Re: 330 Church St, Parramatta – MP10_0171 MOD 8

We write to express our objection to the Application. In short, we do not understand how the Department of Planning and Environment (**Department**), acting reasonably, can approve an Application that will lead to the amplification of a serious and dangerous traffic and pedestrian conflict.

SP 3

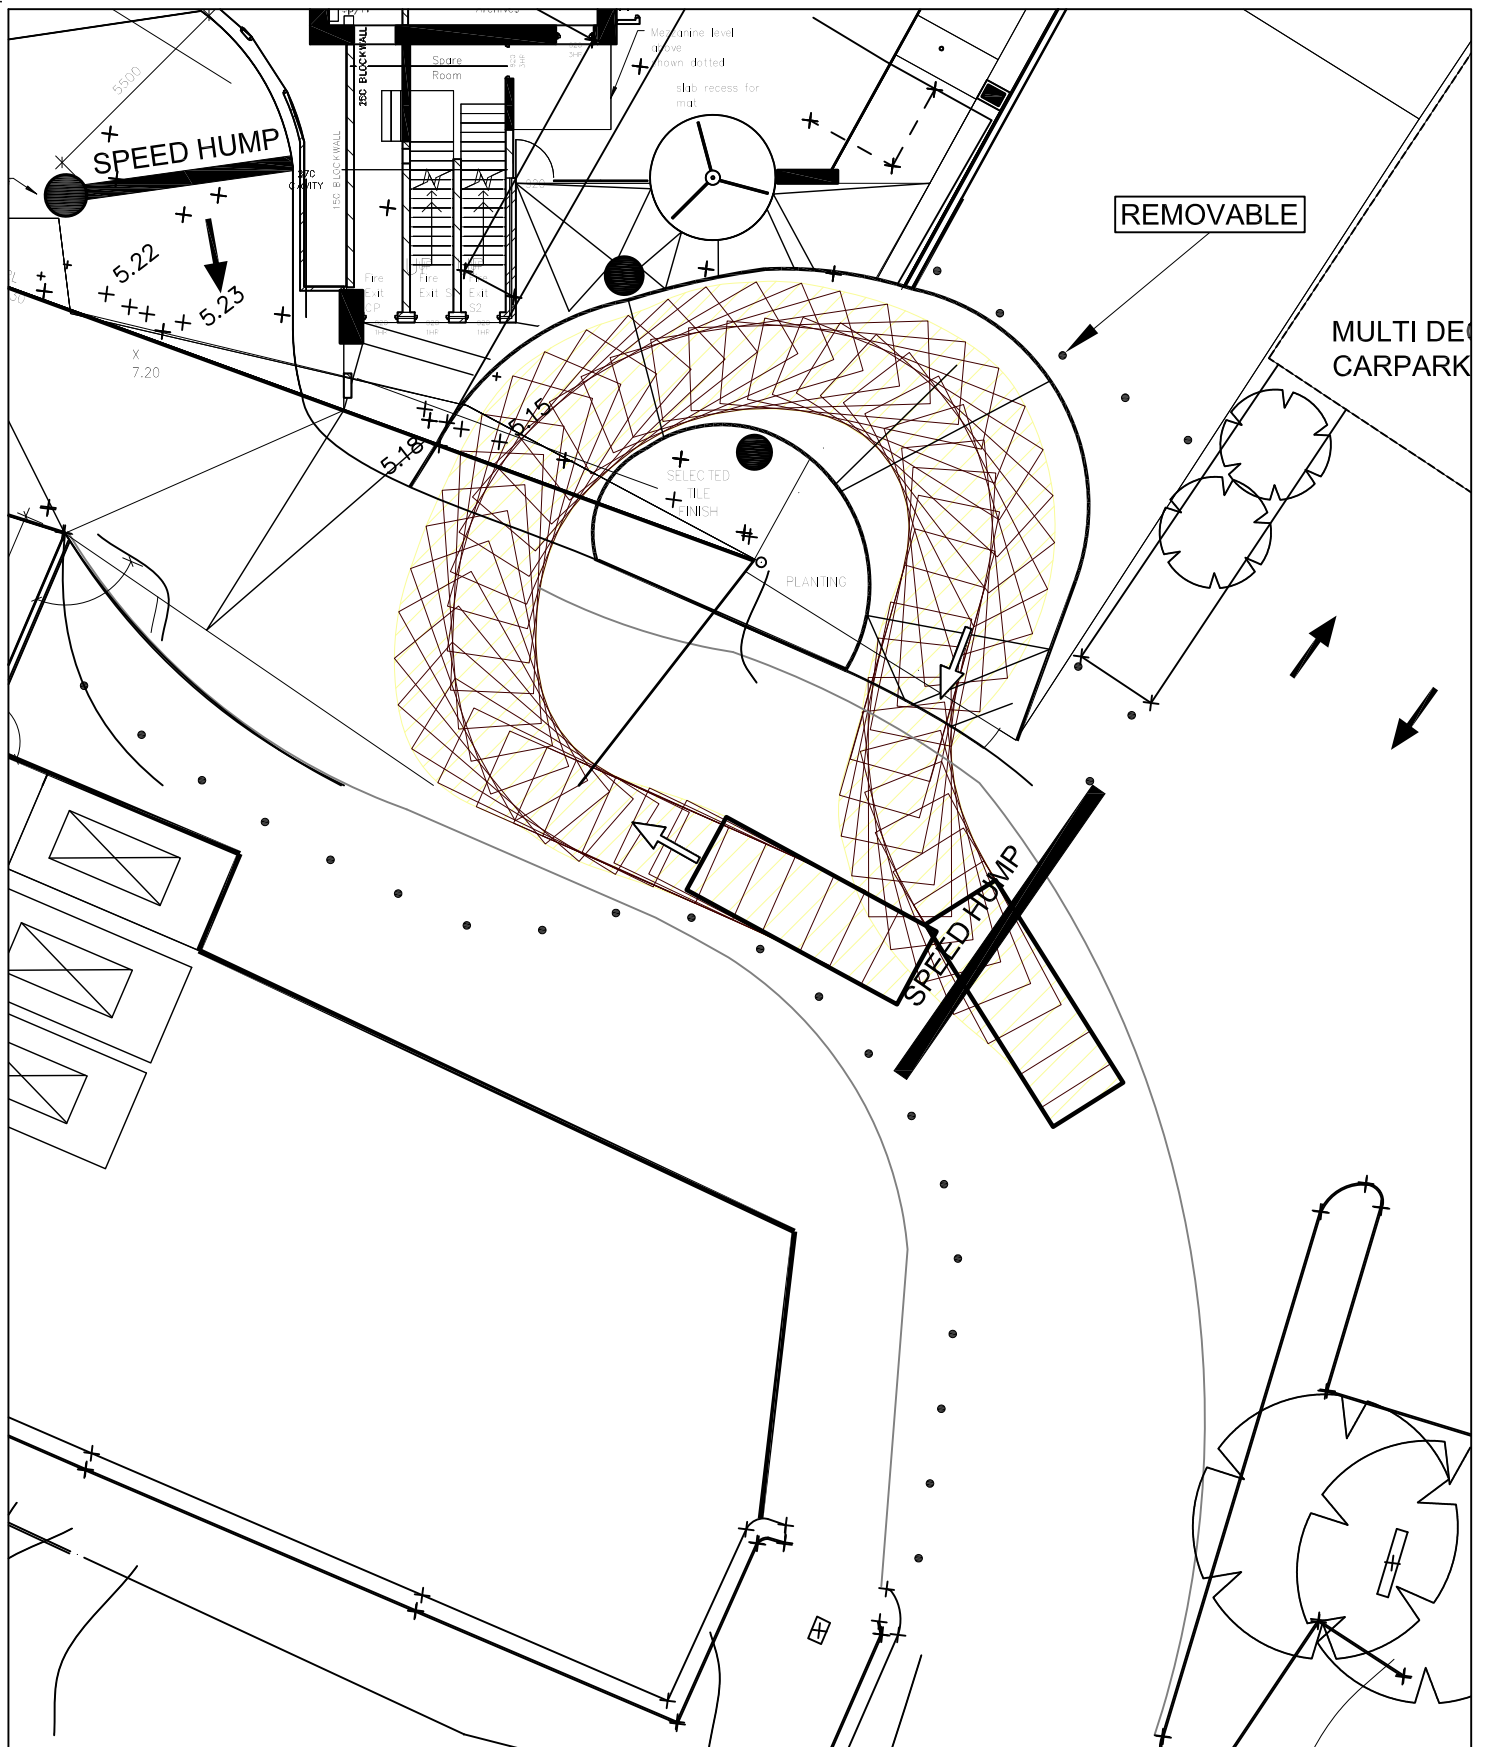
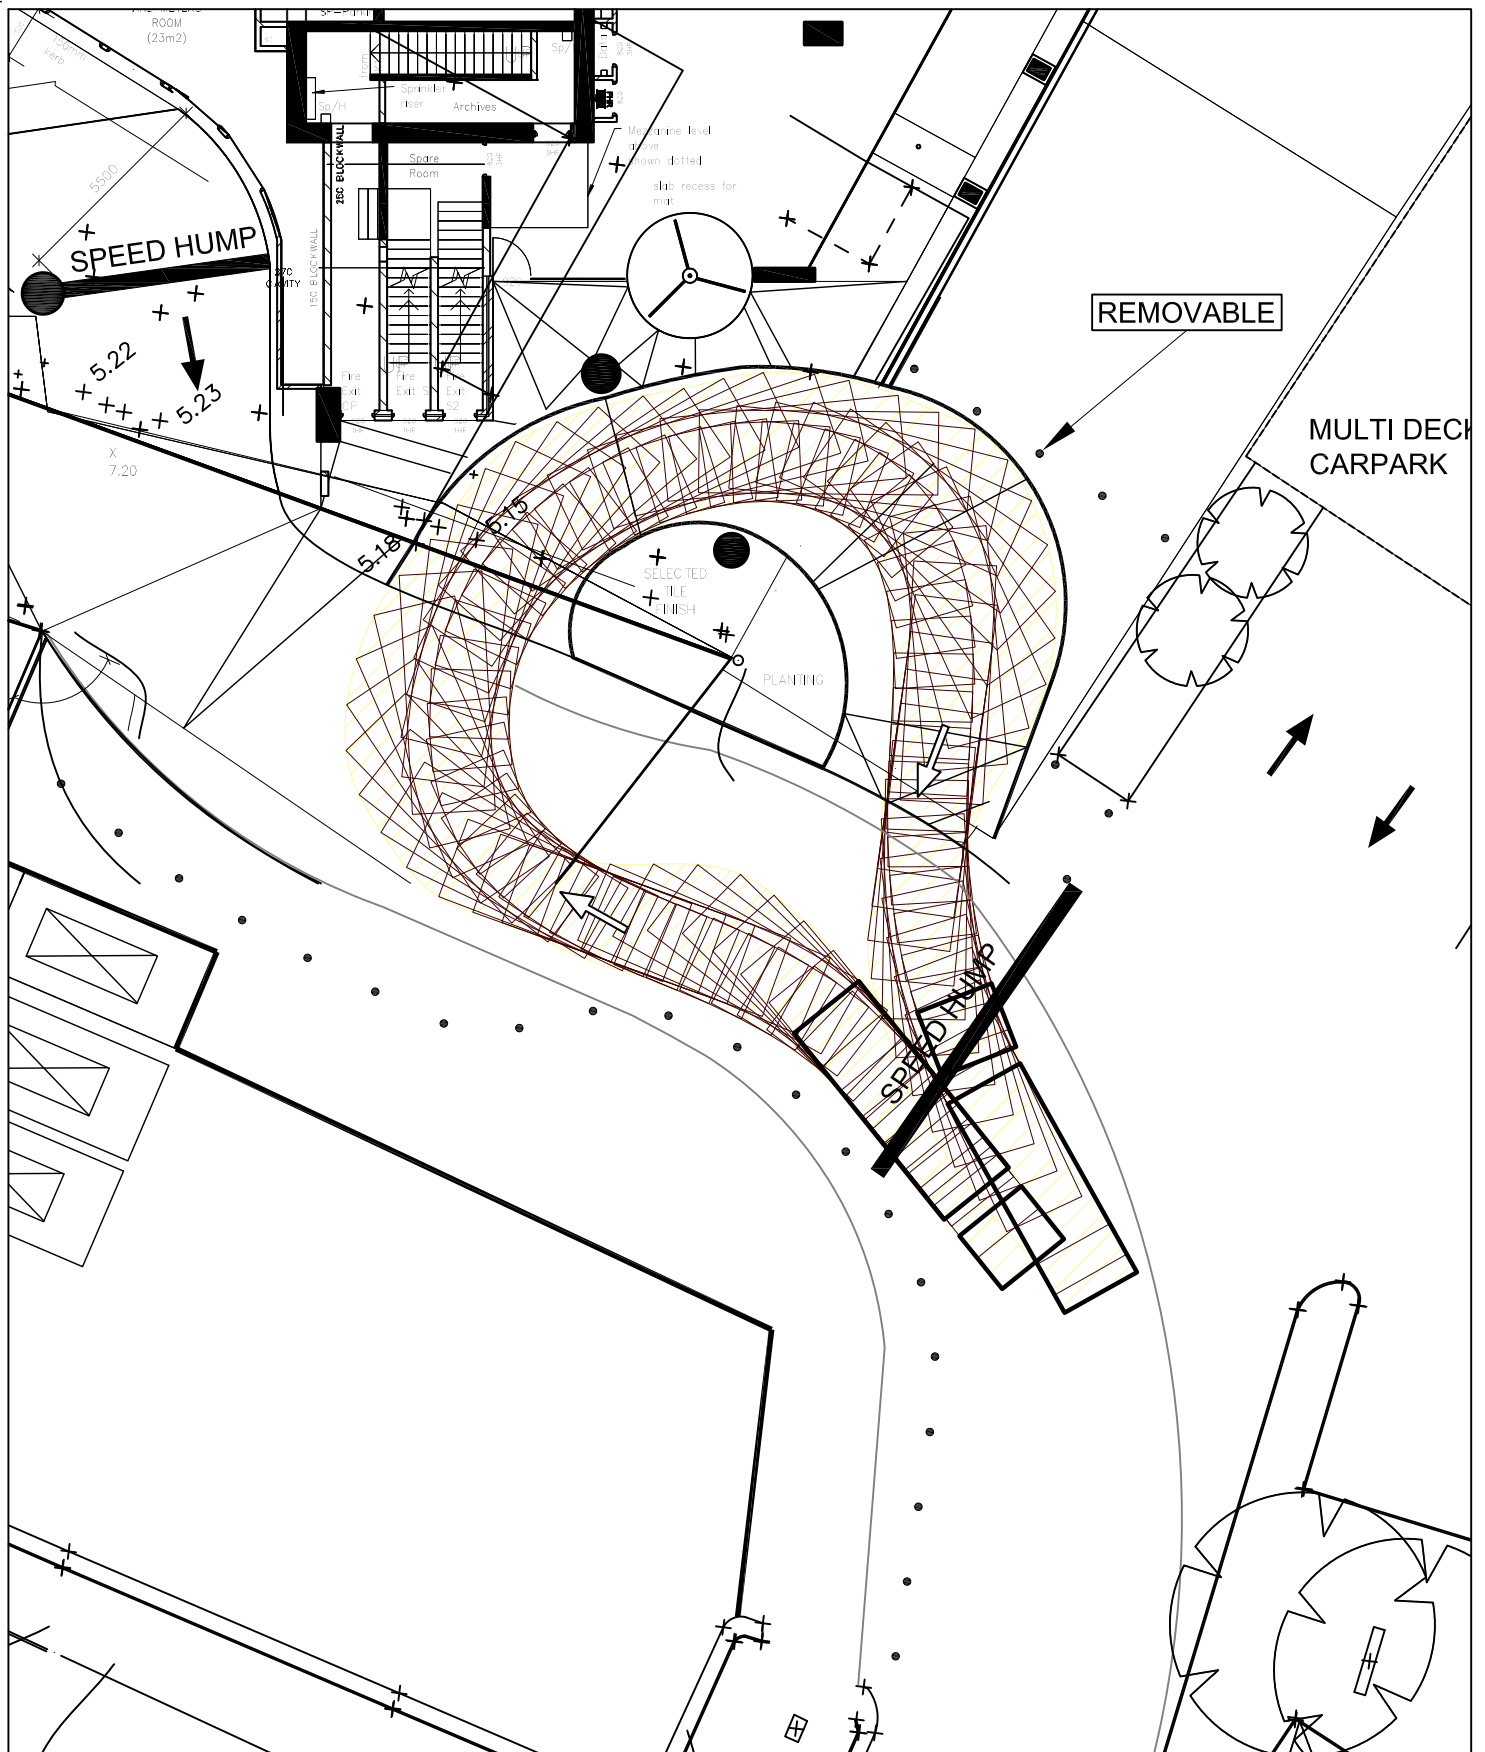
Secondly, the porte cochere modification is not supported by any traffic or safety analysis that calculates the increase in traffic movements; analyses the implications for traffic safety; reviews the way in which pedestrian safety is provided; considers the management of loading, unloading, garbage, deliveries, resident access, visitor parking; and gives an estimate of the porte cochere use and the relationship with other traffic movements in this very small area of land. The traffic analysis is limited to simply the swept turning paths for vehicles.

Clearly a proper traffic, pedestrian and safety analysis should consider more than the “workability” of a driveway, but should thoroughly review the cumulative impacts of the proposal, taken together with other traffic and pedestrian generating uses in immediate proximity to the site.

PROJECT		PROJECT		PROJECT	
RIVERFRONT APARTMENTS		RIVERFRONT APARTMENTS		RIVERFRONT APARTMENTS	
330 CHURCH STREET PARRAMATTA NSW		330 CHURCH STREET PARRAMATTA NSW		330 CHURCH STREET PARRAMATTA NSW	
DRAWING NAME		DRAWING NAME		DRAWING NAME	
ELEVATIONS - SITE		ELEVATIONS - SITE		ELEVATIONS - SITE

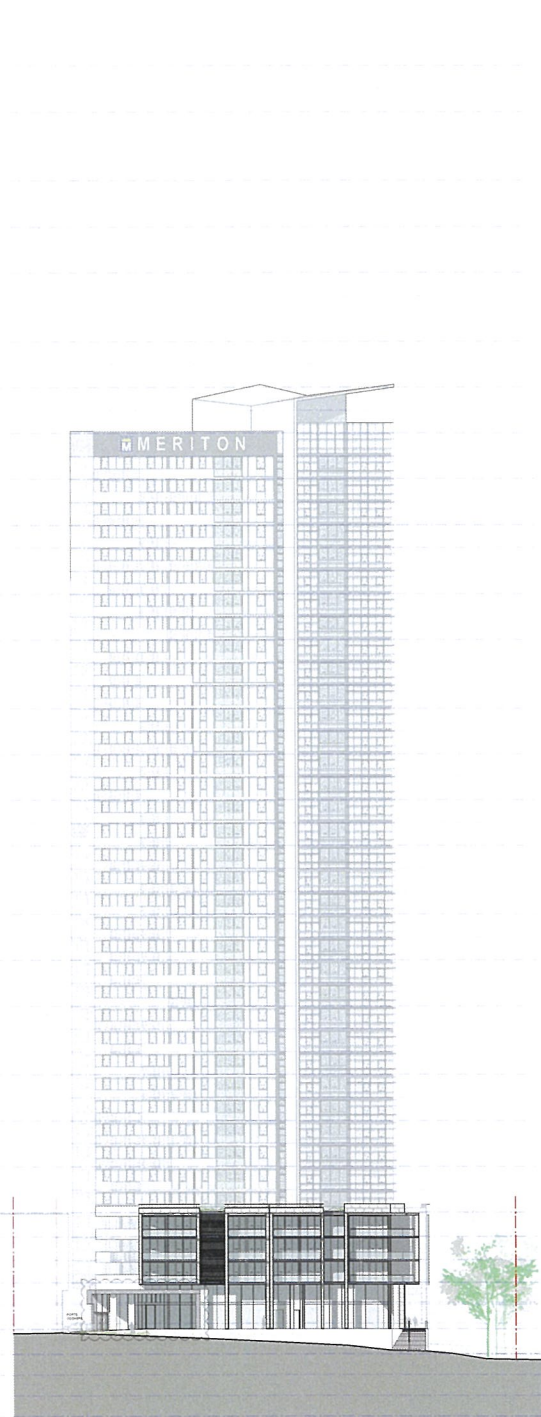
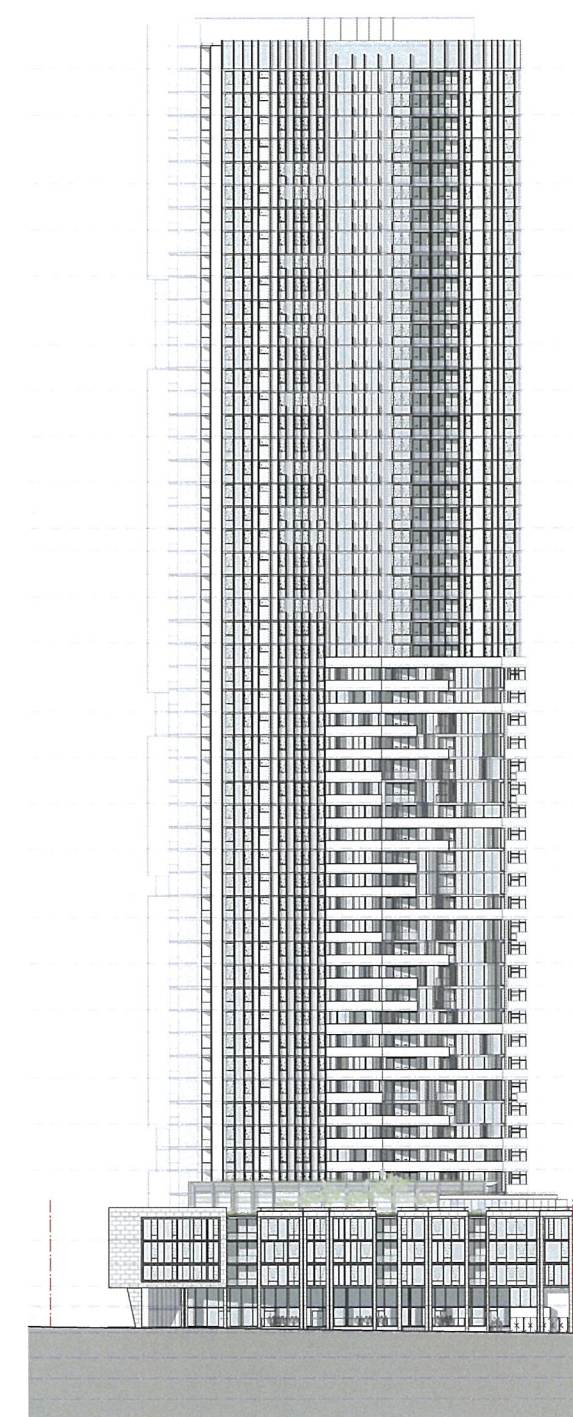
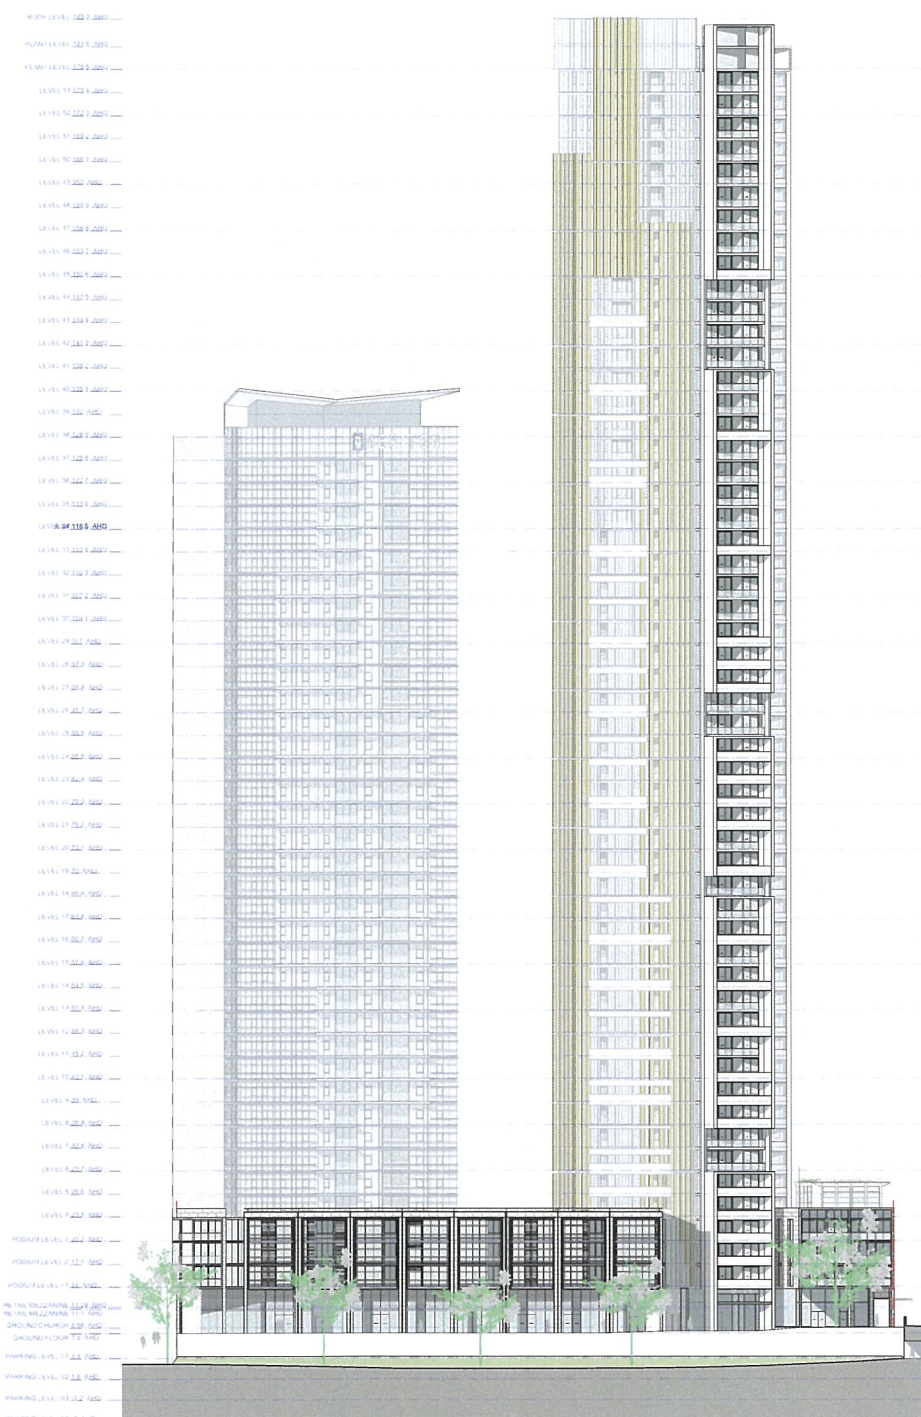
Please refer to the two images below, and note how the approved plan (Modification 6) differs from the proposed plan (Modification 8) in relation to the deletion of the wall that separates the Site from the Meriton Land and provides a small measure of protection through a barrier / wall for patrons exiting and entering the restaurant.

The written report accompanying the proposal fails to acknowledge this fundamental amendment, which was intentionally sought by the PAC as part of Modification 3. The continued eroding of safety measures; along with the ongoing amplification of unsafe conditions are hallmarks of the modification applications. We appeal to the Department to carefully observe the pattern and finally act to stop any further modification that we exacerbate safety matters even further.
